**Tweed Valley Hospital Multi-Deck Carpark
SSD3 AMENDMENT REGISTER****DCR-SSD3**

We issue herewith the list of changes made on the drawings as sent in the nominate transmissions.

Transmittal Date 16.09.2022

B PLAN FS211 / FS262
Scale: 1 : 50

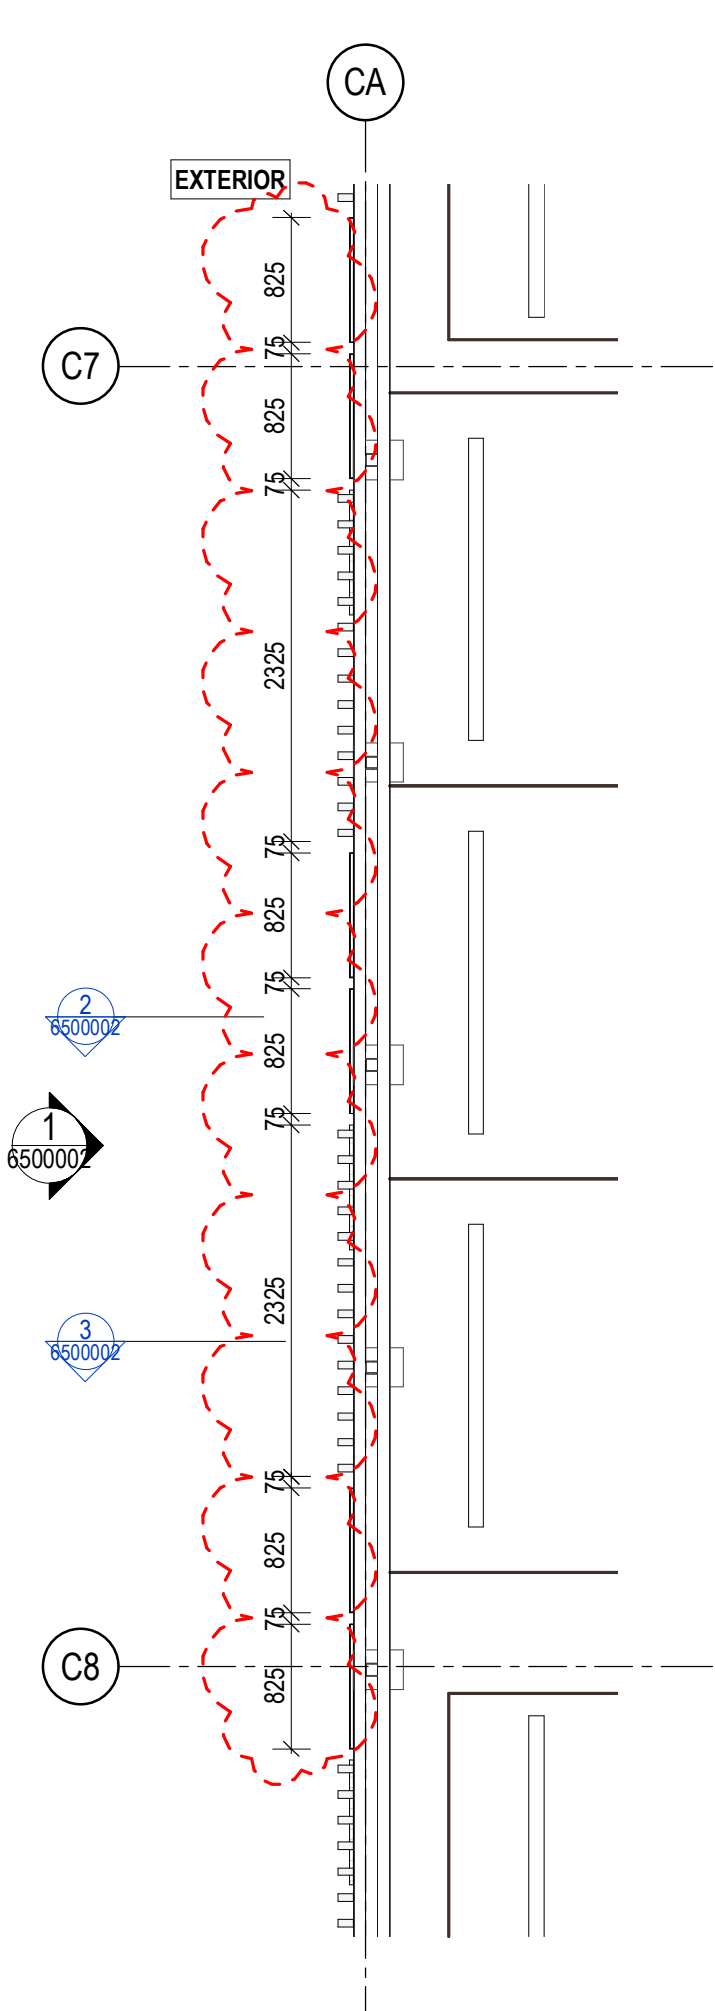
3	Café Tenancy Space added	
			4	Space for Mechanical Exhaust Fans shown in Female	
			5	Operators Office and Fit out adjusted For AS1428.1 compliance	
			6	PWD Amenities Door Relocated	
			7	FHR and Hydrant add to B1 Grid CC as part of design development	
MDD-AR-SKE-MCP-6500001	FAÇADE TYPES	5	1	Façade Types amended to meet requirements of FEBQ and FRNSW - refer to finishes schedule for further detail	
MDD-AR-SKE-MCP-6500002		5	2	Powdercoat colour codes removed, refer to finishes schedule for colour selections	
MDD-AR-SKE-MCP-6500003		5			
MDD-AR-SKE-MCP-6500004		5			
MDD-AR-SCH-SSD2-001	FAÇADE SCREEN SCHEDULE	4	1	Façade Screen type FS-211a perforation pattern amended to meet the requirements of natural ventilation of open deck carpark as stipulated by FRNSW	
			2	Façade Screen type FS-211b perforation pattern amended to meet the requirements of natural ventilation of open deck carpark as stipulated by FRNSW

3	Façade Screen type FS-265b and FS-265c added to meet the requirements of natural ventilation of open deck carpark as stipulated by FRNSW and colour selection enhances and articulates massing and multi-level expression from the Main Hospital Building
